Re: Rocky Mountain Calvary Chapel – Ellicott Site Development Plan

This firm represents the Upper Black Squirrel Creek Ground Water Management District (the “UBSC District”), a formed and operating ground water management district with the powers enumerated in the Colorado Ground Water Management Act, C.R.S. § 37-90-101 *et seq.* The UBSC District has reviewed the Rocky Mountain Calvary Chapel – Ellicott Site Development Plan (the “Project”) submitted by M.V.E., Inc. (“Applicant”) for an application to allow a new building addition to the existing church site include new site access, parking, landscaping, grading, utilities, and storm detention/water quality treatment pond and provides the following comments for your review and consideration:

GRADING & EROSION  
CONTROL PLAN  
POND PLAN

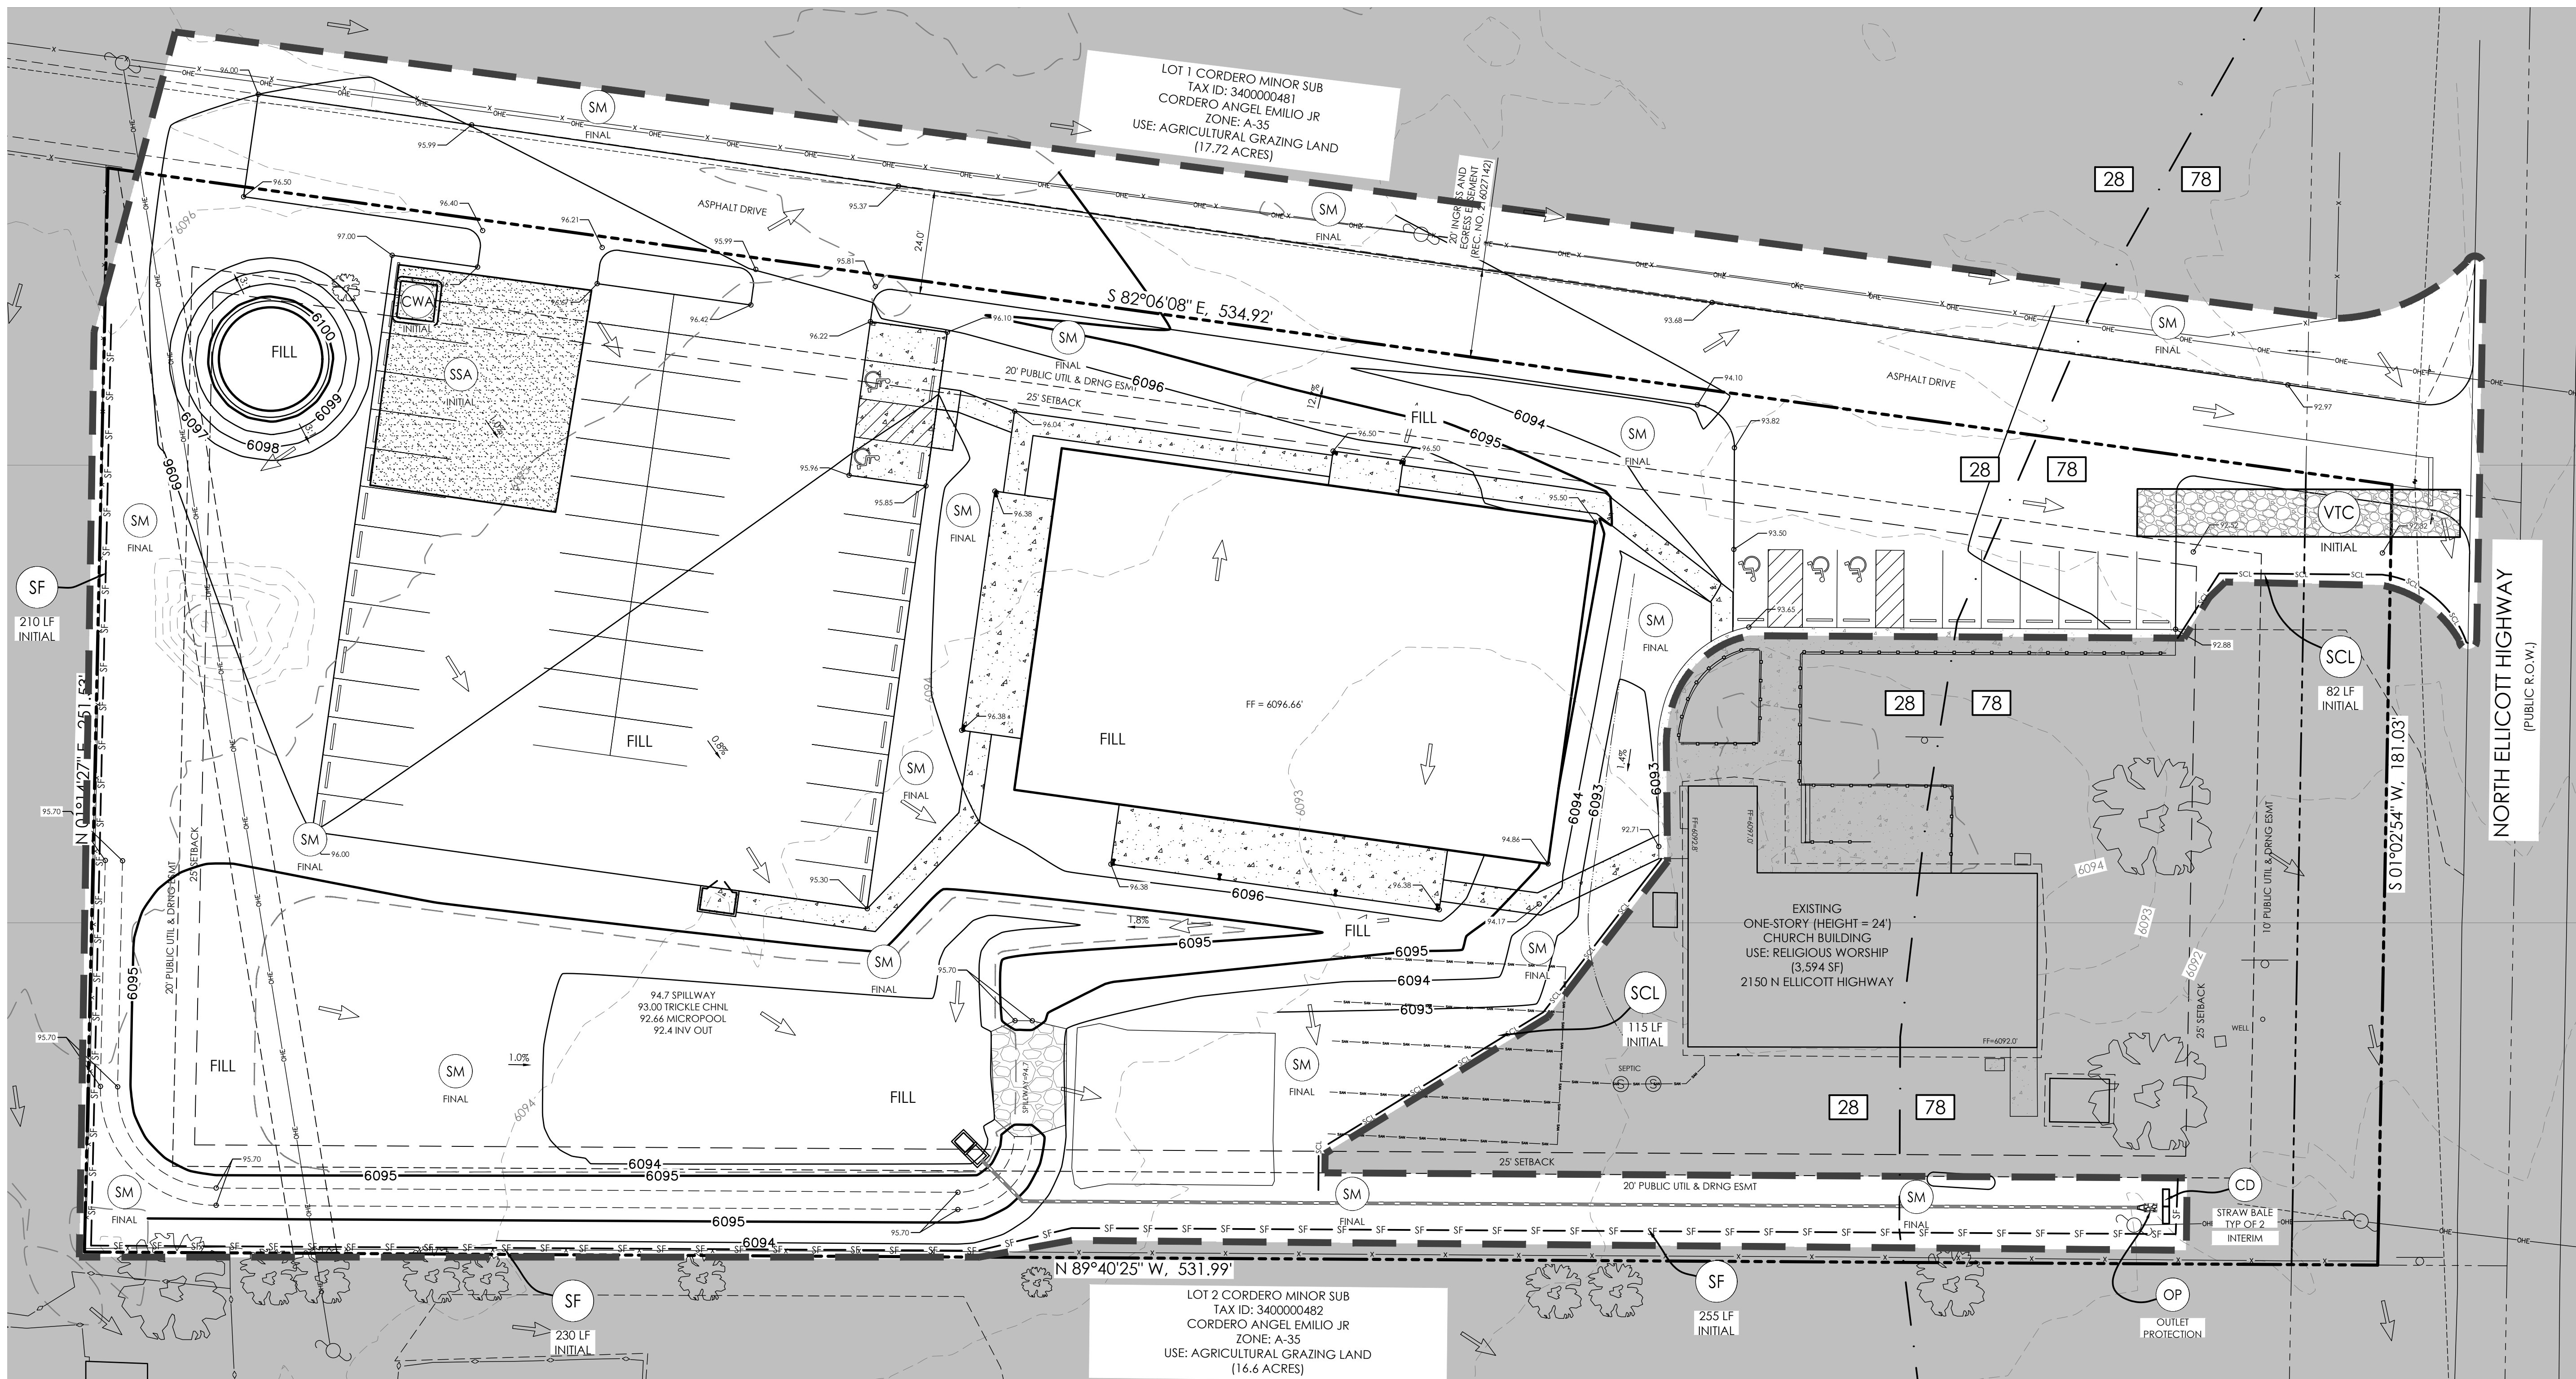
The Project may not capture and detain surface flows within the UBSC Basin unless done so by a proper stormwater detention facility in accordance with Designated Basin Rule 5.11. Surface flows in a designated basin are “designated ground water” under the Groundwater Management Act and are subject to administration by the Ground Water Commission. *In Matter of Water Rights*, 361 P.3d 392, 396–97 (Colo. 2015); *see also* C.R.S. § 37-90-102(1) (stating that designated ground water may only be appropriated in the manner prescribed by the Groundwater Management Act). Accordingly, it is illegal to capture and detain such flows unless done so by a proper storm water detention facility in accordance with Rule 5.11, which includes (among several other requirements) as follows:

5.11.1 A “storm water detention and infiltration facility” means a facility that is operated solely for storm water management and:

Is owned or operated by a government entity or is subject to oversight by a governmental entity;

Continuously releases or infiltrates at least ninety-seven percent of all of the water from a rainfall event that is **equal to or less than a five-year storm** within seventy-two hours after the end of the rainfall event;

Continuously releases or infiltrates all of the water from a rainfall event **greater than a five-year storm** as quickly as practicable, but in all cases releases or infiltrates at least ninety-nine percent of all of the water from the rainfall event within one hundred twenty hours after the end of the rainfall event, and:

Operates passively and does not subject the storm water runoff to any active treatment process.
